From: Amanda Scholes on behalf of Planning.Responses
Sent: 01 July 2020 09:40
To: Planning Scanning
Subject: FW: F/6/20/DOC FW: 23314 Wick Farm, Ford - Arun Drainage Response
Attachments: Althon R10CA Headwall + 400mm Toe + Hinged Cranked grating.pdf; Althon R20B_Datasheet_and_Installation_Guide.pdf; 10_D_Site Layout.pdf; 21_D_Drainage and Levels - 1 of 6.pdf; 22_D_Drainage and Levels - 2 of 6.pdf; 23_D_Drainage and Levels - 3 of 6.pdf; 24_D_Drainage and Levels - 4 of 6.pdf; 25_A_Drainage and Levels - 5 of 6.pdf; 26_A_Drainage and Levels - 6 of 6.pdf

From: Stuart Magowan [REDACTED]
Sent: 17 June 2020 10:12
To: John Hall [REDACTED]
Cc: Andrew Hawes [REDACTED] Stuart Lever [REDACTED]
[REDACTED] Mark Wren [REDACTED] Lee Clarke [REDACTED]
[REDACTED]; David Moore [REDACTED]; Steve Burgess [REDACTED] CEP | Reception [REDACTED]
Subject: 23314 Wick Farm, Ford - Arun Drainage Response

We have now completed the run through of the comments received from Paul Cann at Arun District Council and have updated the design drawings and details as discussed. The following link will allow a download of the updated information for the team to review:

GRAVEL CAR PARK CONSTRUCTION
DETAIL D
(Scale 1:20)

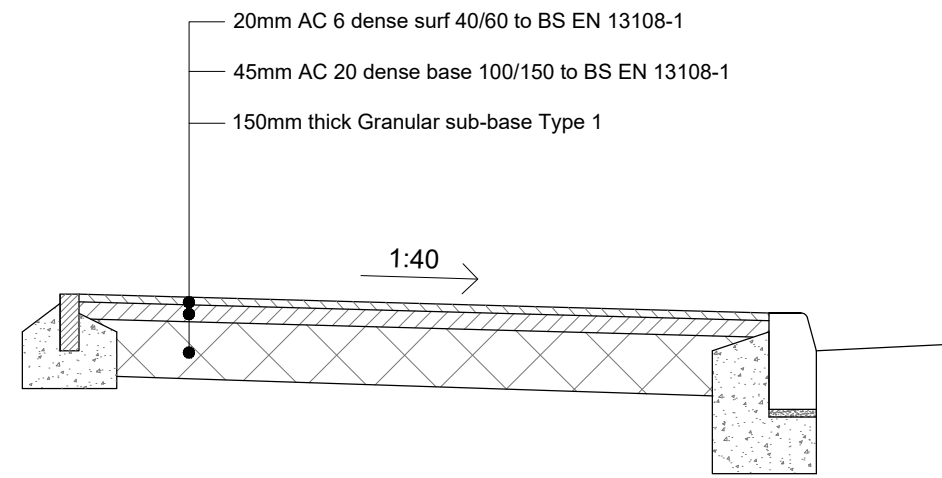
18. Car park area draining to swale 2 – is the surface to be of permeable construction? Provide fully detailed construction details. Provide perforated pipe construction details including structure on downstream end of pipes. Specify how upstream ends of pipes are to be terminated. Specify pipe invert levels/gradients.

The car park area draining to Swale 2 surface is permeable as per the detail on drawing 52. Further notes have been added to drawing 25 showing the Invert Level depths of the perforated Fin Drain.
